Please ask for: Ms Iqraa Malik
Email: iqraa.malik@terraquest.co.uk
Telephone: 01212341390
Our Ref: LU/257/20/HH
Your Ref:
Date: 23rd September 2020

Application for Planning Permission for Works or Extension to a Dwelling

Development: Two storey brick side extension under tiled roof
Location: 2 Meadow Way Littlehampton BN17 6BW

BLOCK PLAN 1:200

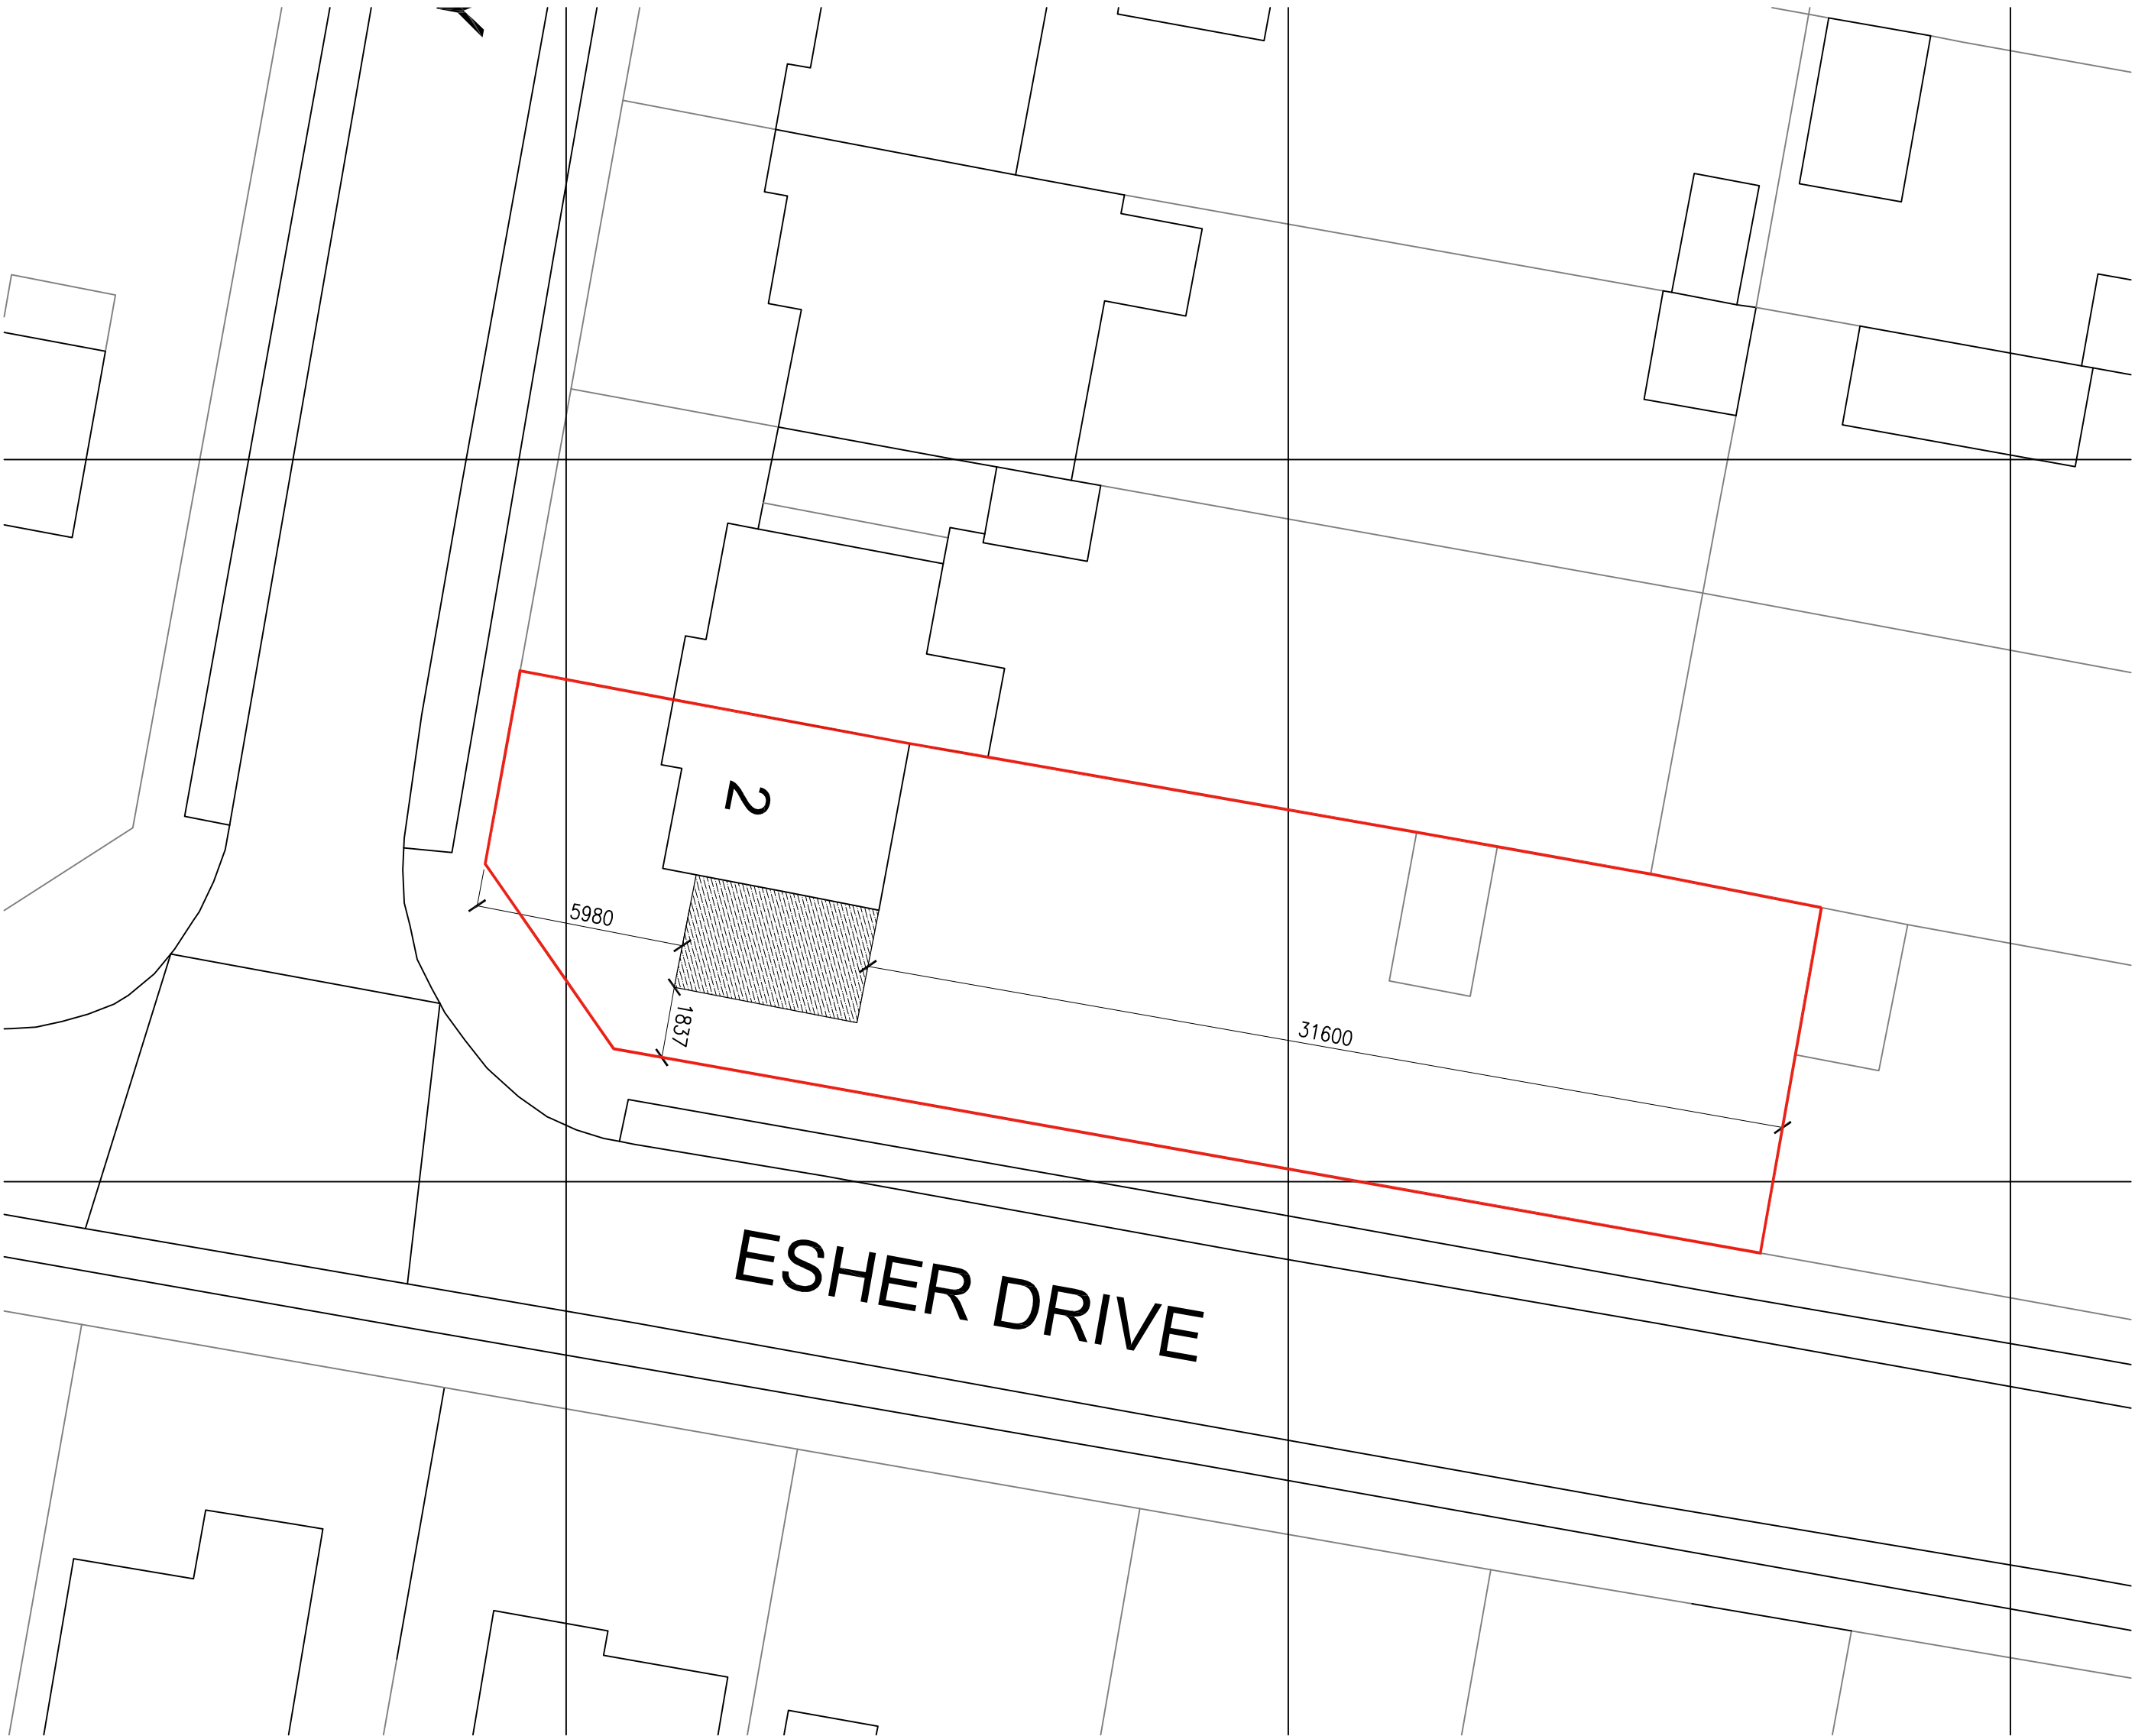
Block Plan

You are required to have dimensions from the proposed extension(s) to all site boundaries. Please amend.
